ATTENTION: Department of Planning, Housing and Infrastructure
PROJECT: Deniliquin East Battery Energy Storage System SSD-61612229

Re: Submission for Exhibition for State Significant Development Application - Deniliquin East Battery Energy Storage System - 21356 Riverina Highway, Deniliquin.

Please find below Edward Rivers Council's submission in relation to the Environmental Impact Statement (EIS) and supporting information for the Deniliquin East Battery Energy Storage System development (SDD-61612229). Council understands the Project seeks approval for the construction, operation and decommissioning of a battery energy storage system (BESS) with the capacity of 100 MW/200MWh and ancillary infrastructure on Lot 11 DP856212.

Figure 21 Landscape Planting Strategy

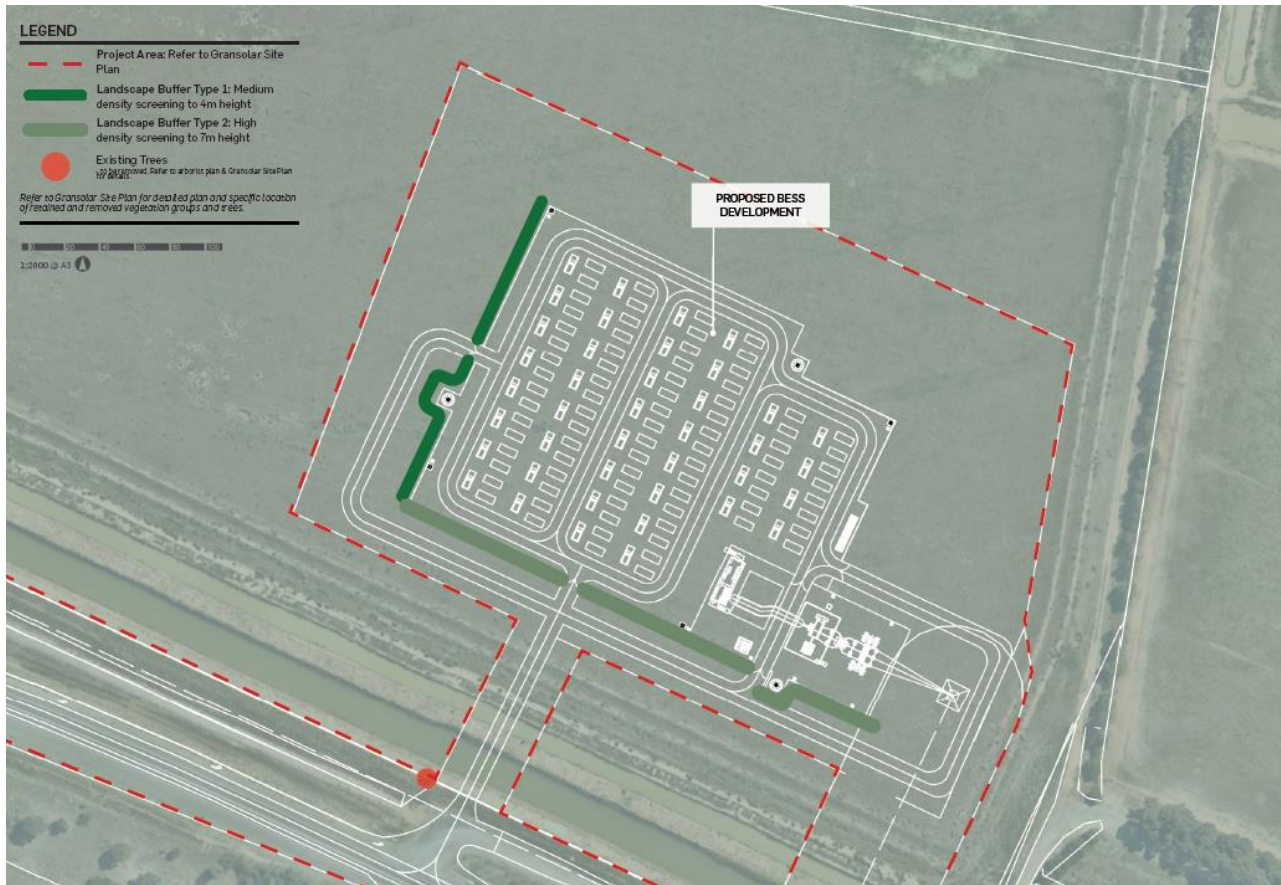
The planting associated with the landscape screen as outlined on the proposed landscape plan must be maintained while the development is in operation at the site. On-going monitoring of the health and performance of the visual plant screen during the life of the operation must be undertaken, including replacement of plant stock whenever necessary to ensure the screen continues to act as an effective visual buffer. Following construction, restoration of ground cover to the site should be undertaken as soon as practicable, using suitable local species to maintain ground cover.
